## Memorandum

Date: March 11, 2008  
To: Carmen Moran  
From: Slade Strickland  
Subject: **Case 1554-Z/Best Publishing**

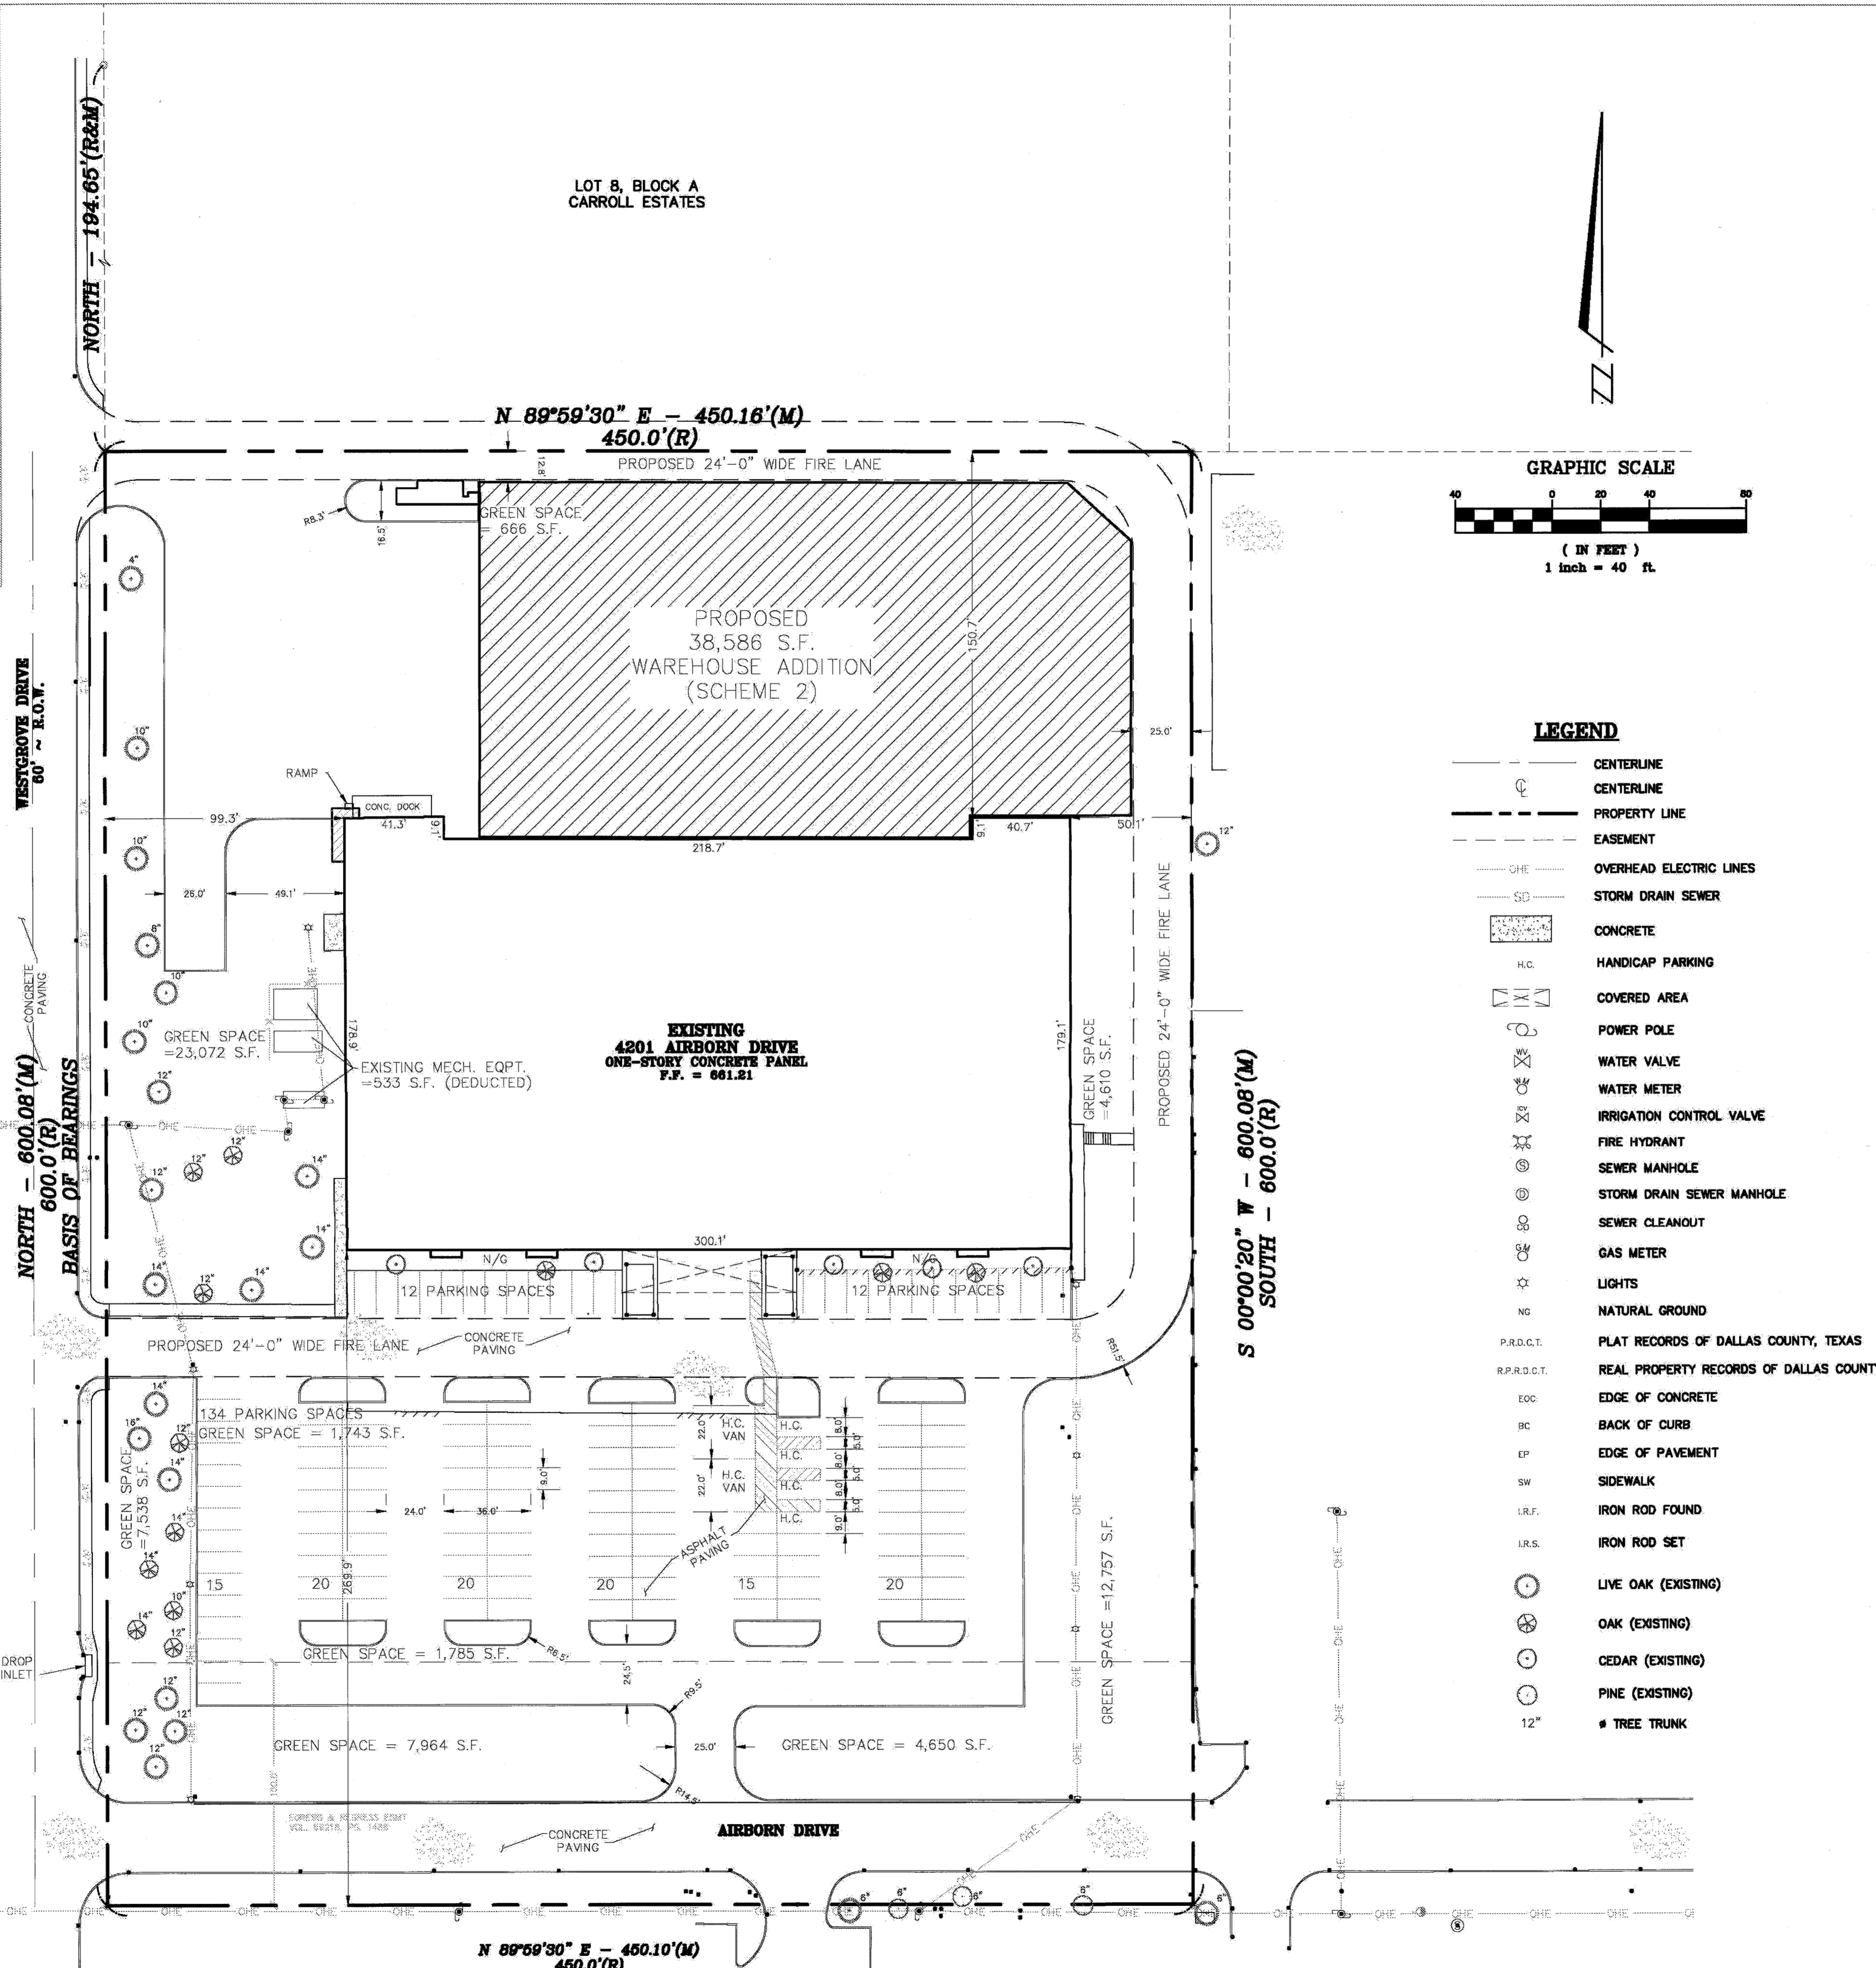
The landscape plan submitted by the applicant meets the 20 percent landscape requirement; however it does not provide for a perimeter landscape buffer along the north property line. Presently, there is a landscape buffer on the north side of the property consisting of live oaks and evergreen shrubs shown to be removed completely due to site constraints with the building expansion and the requirement to provide a fire lane. The applicant proposes to offset this by adding additional landscaped area on the south side of the site along Airborn Drive.
